# Steeple Renewables Project

**Applicant Response to Rule 17 Letter dated 02 April 2026**

Document Reference: EN010163/EX/8.60

Figure 7.13.1: Skylark mitigation in the Western Biodiversity Mitigation Area

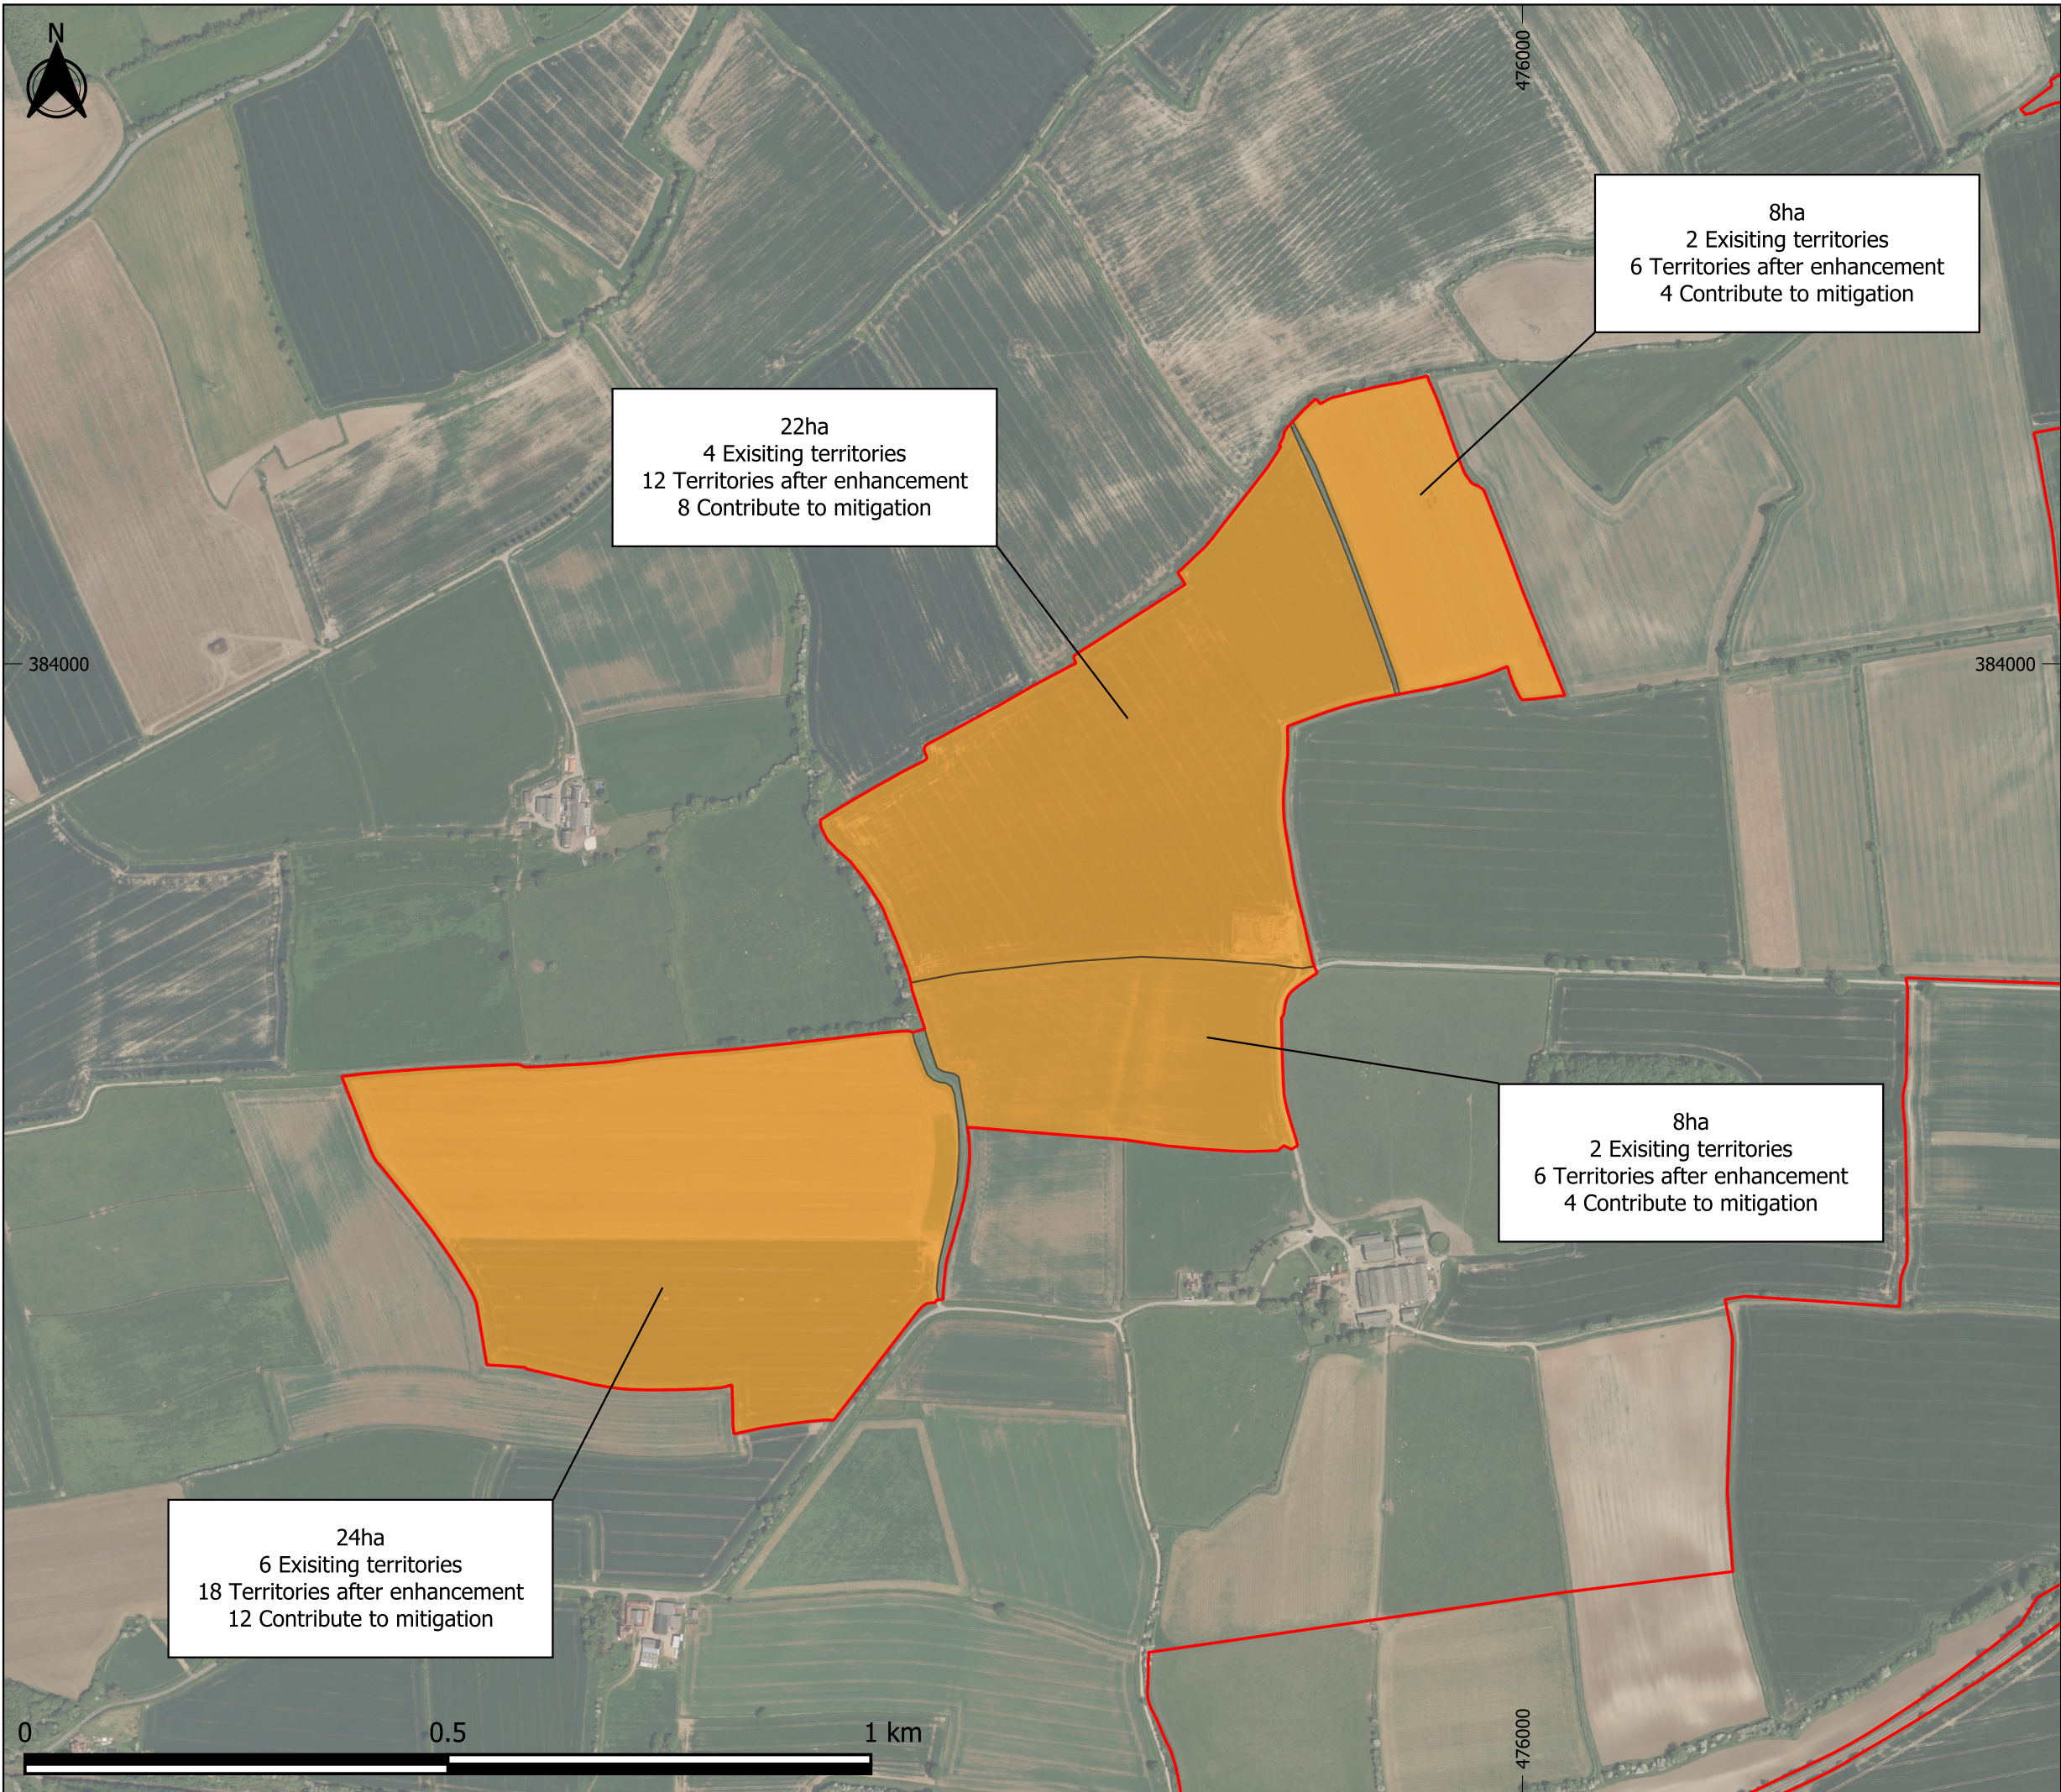
ID	ExA Question	Applicant Response
PD-010/1	<p><b>Biodiversity and Ecology - Skylark</b></p> <p><b>Applicant:</b> During issue specific hearing 2 agenda item 6, and as summarised in Written Summaries of Oral Submissions [REP4-031], it was stated that there is no policy requirement to provide like-for-like or 100% replacement for skylarks or other Section 41 species. Explain whether the proposed mitigation and compensation measures has fully applied the mitigation hierarchy in respect of avoiding, mitigating and compensating significant harm to skylark. If not, explain why not.</p> <p>In addition, the Planning Statement [REP2-040] (Appendix C page 117) states that there would be "no residual significant adverse effects on any species and habitats as a result of the Proposed Development". Yet chapter 7 of the Environmental Statement (ES) [REP3-009] concludes there would be residual significant effects (including cumulative) on skylark. Clarify whether there is a discrepancy between the documents. The applicant is also requested to review the accuracy of the figures in paragraph 6.5.29 and 6.5.30 of the Planning Statement which appear to differ from those quoted in the ES.</p>	<p><u>Skylark / Mitigation Hierarchy</u></p> <p>The mitigation hierarchy has been appropriately applied to impacts on the skylark population as set out below. In this regard we also note the following statement by Bassetlaw District Council at reference BDC3 on page 9 in their SoCG [REP3-047]:</p> <p><i>“Species groups have all been addressed individually, with priority given to protected and threatened species. Species that habitually rely on the current arable landscapes for their lifecycles, notably skylark for example, have been carefully considered and detailed mitigation and compensation has been designed into the scheme...”</i></p> <p><i>Avoidance</i> - By their nature skylarks have particular habitat requirements that include open fields which cannot be provided within the main body of the development apart from in a relatively small number of locations.</p> <p><i>Mitigation</i> - Mitigation includes retention of areas within the main solar farm development large enough to support skylark nesting. However, it is not possible to fully mitigate the loss of all potential territories within the body of the development.</p> <p>Other designed-in mitigation measures include the provision of retained field margins and swathes of grassland that will provide enhanced foraging opportunities for the local skylark population during the breeding season, as well as being managed to provide enhanced foraging for overwintering skylarks. This further mitigation will increase the survival of skylarks throughout the year, thereby reducing the impact on the species locally.</p>

*Compensation* - In the east and west biodiversity areas, land for compensation has been provided. Measures to increase the two areas' carrying capacity for skylark will further reduce the number of territories lost. Putting in place enhanced field margin foraging and "beetle banks" will provide increased local foraging during the breeding season as well as through winter. While numerically there is a small number of territories that will not be replaced, the provision of skylark plots and targeted skylark management will give increased opportunities for multiple broods within a season (meaning greater skylark productivity). Enhanced local foraging in the biodiversity areas will also increase productivity among the local skylark nesting population, as well as provide a year-round increase in foraging which will benefit the local population of skylark as a whole (not just during the breeding season). It should also be noted that targeted management for skylarks will be over an extended period of 40 years which provides long-term favourable conditions for the species.
